Our ref: HA/2019/121602/01-L01
Your ref: FP/185/19/PL
Date: 19 September 2019

DETACHED DWELLING - RESUBMISSION OF FP/201/18/PL

MERMAID AND PLAYBOX SEA ROAD FELPHAM PO22 7AW

FIRST FLOOR PLAN

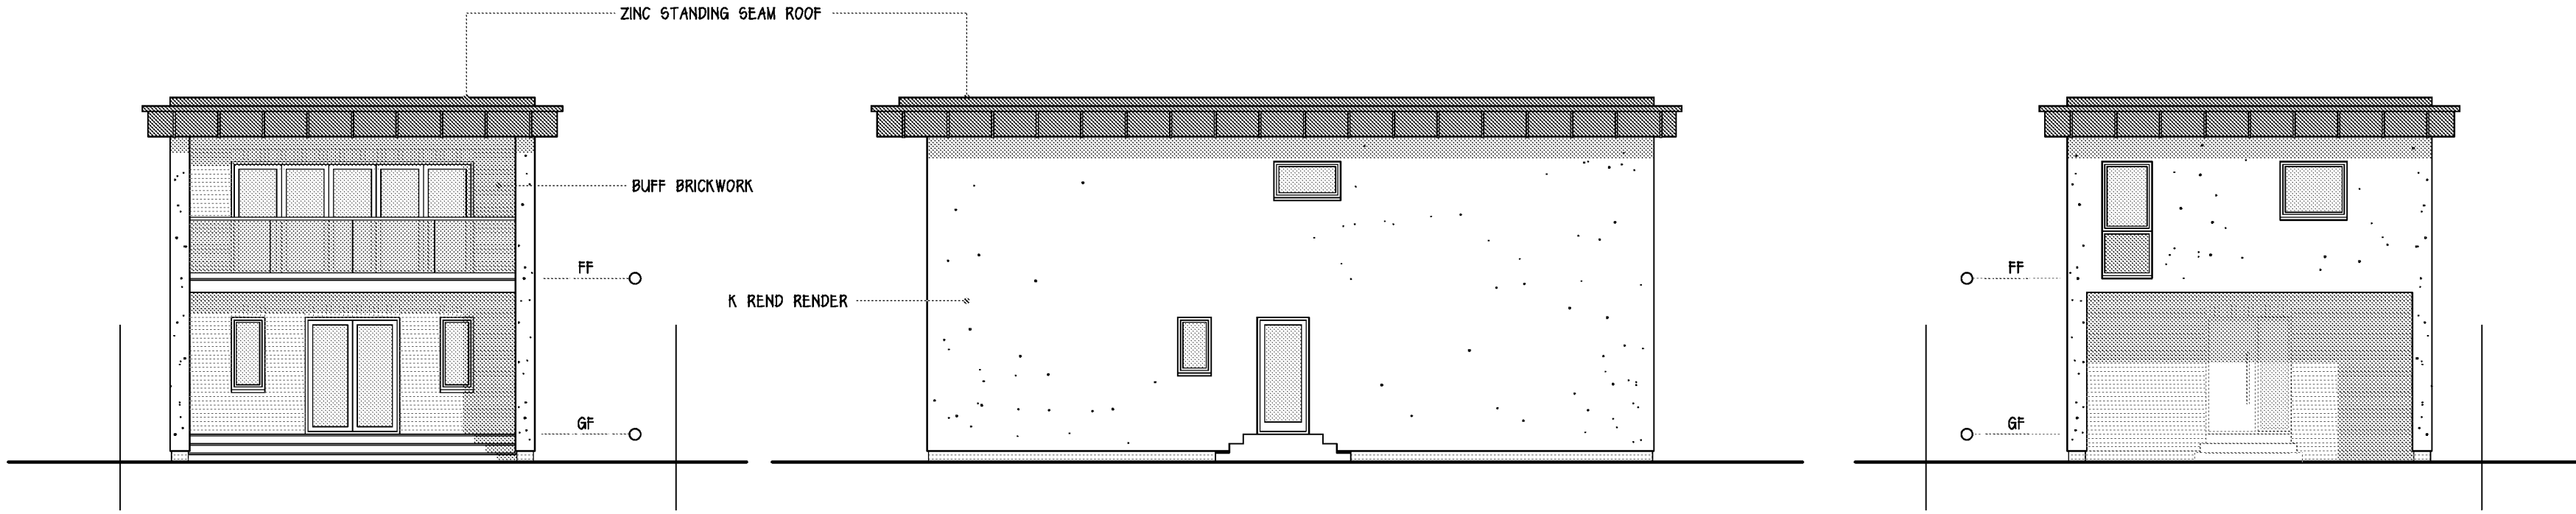
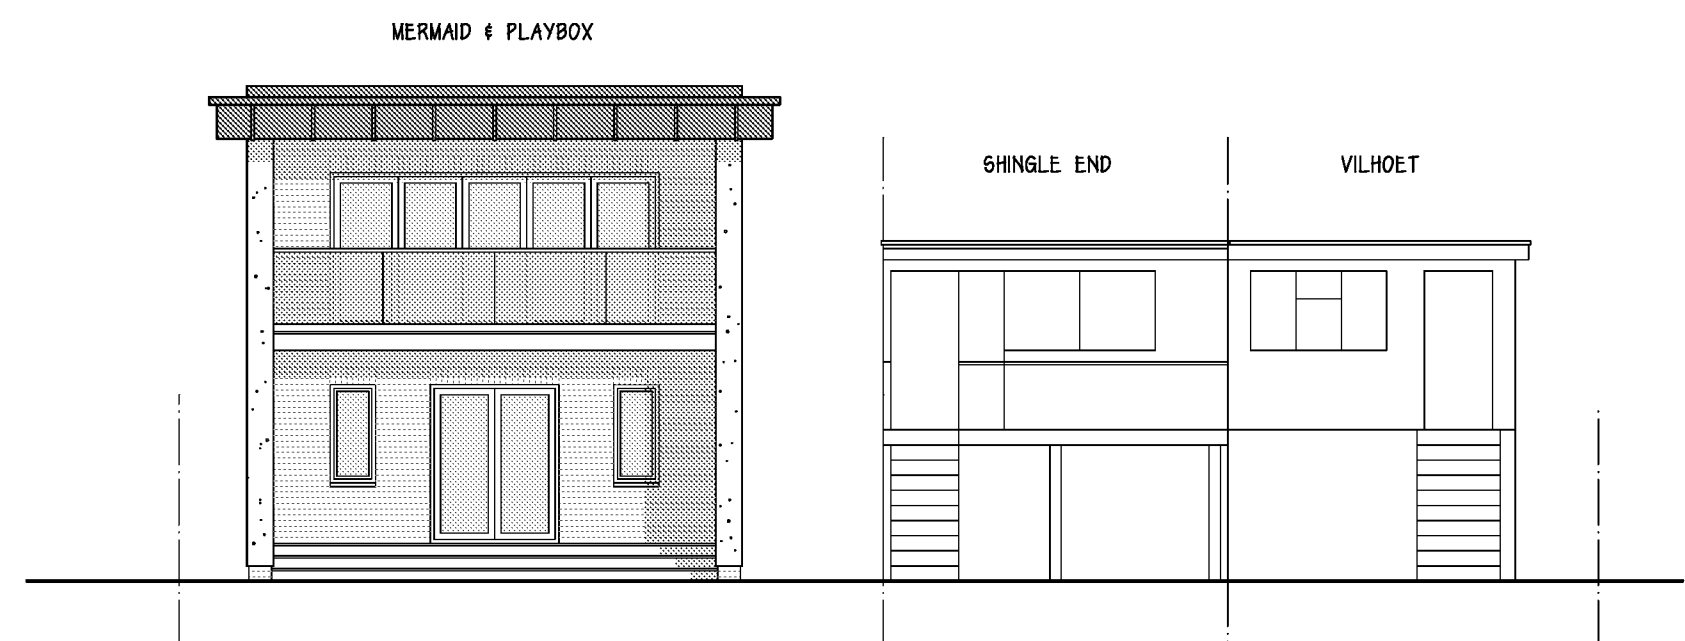
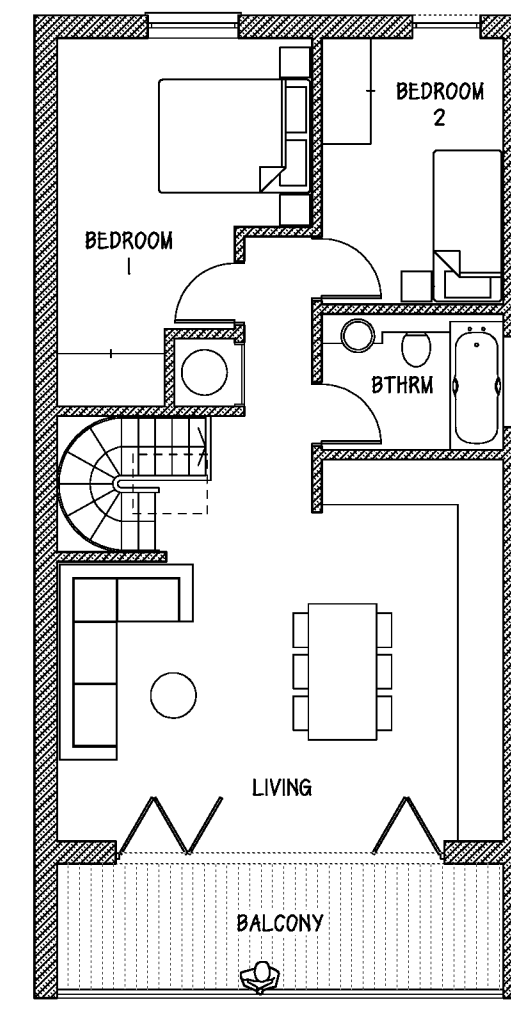
The application does not demonstrate that occupants can remain safe for the lifetime of the development, we would recommend that sleeping accommodation should not be placed on the ground floor in this location.
